From: Richard Martin
Sent: 02 May 2017 17:04
To: David Easton
Subject: RE: (No. 139) R/38/17/T Willow Cottage 2 Botany close Rustington

From: Richard Martin [REDACTED]
Sent: Monday, April 10, 2017 4:24 PM
To: har [REDACTED]
Subject: (No. 139) R/38/17/T Willow Cottage 2 Botany close Rustington

I understand the owner of No. 4 Botany Close (with whom there is a some history) has put in this application at No.2 Botany Close; which doesn't tally with the "Various surgery to 1No. Monterey Pine" that's on the list.

Monterey Pine locations of 2 Botany Close

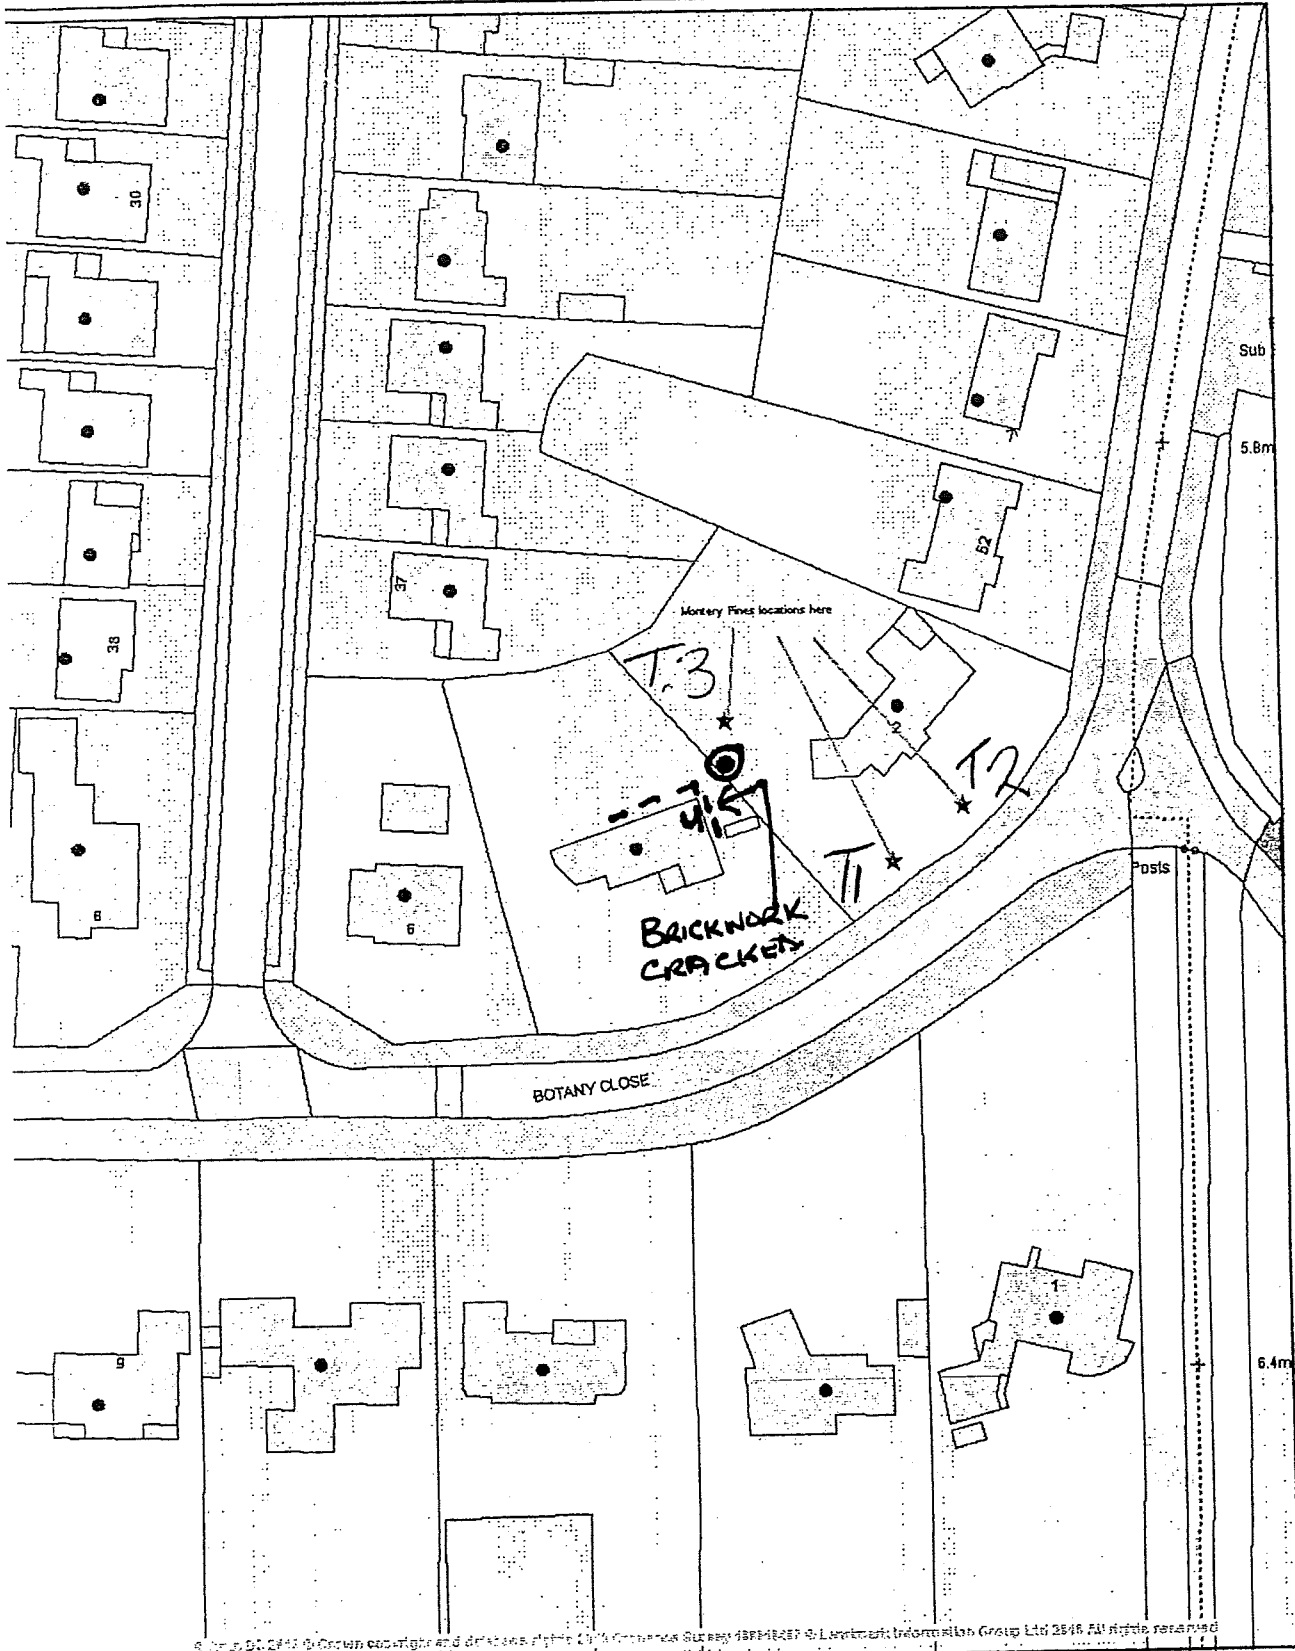
To confirm, Bernie said he will need to see the DVD if we are to permit root severance – to prove that it is necessary and not fictitious.

My concern is the application only talks about removal of roots from drains.

Which doesn't give you a basis to form a decision, as things stand it's only about the drains (for which you would need to see a copy of the DVD).
